Online Comment

Application H16-1051-25
Location LLOYDS TSB BANK PLC 15 MARKET PLACE SPALDING PE11 1SF
Proposal External handrail to entrance steps

Name Spalding & District Civic Society
Address Spalding

PROPOSED HANDRAIL ELEVATION
Scale 1:50

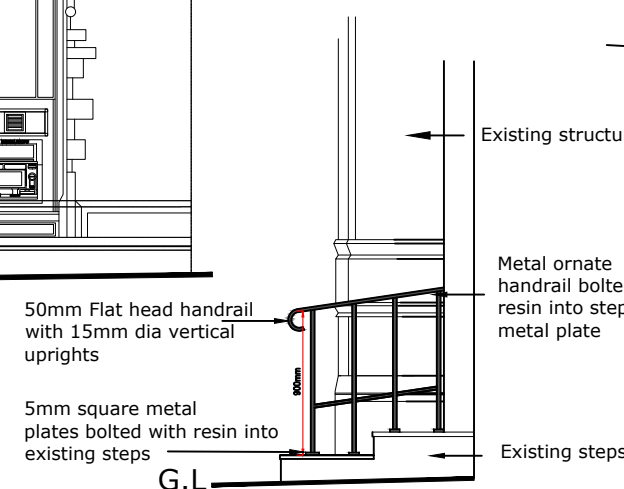
The design of the handrail is sympathetic to the listed building and the intrusion of the fixings to the stone steps is minimal. Therefore we have no objections to this work.
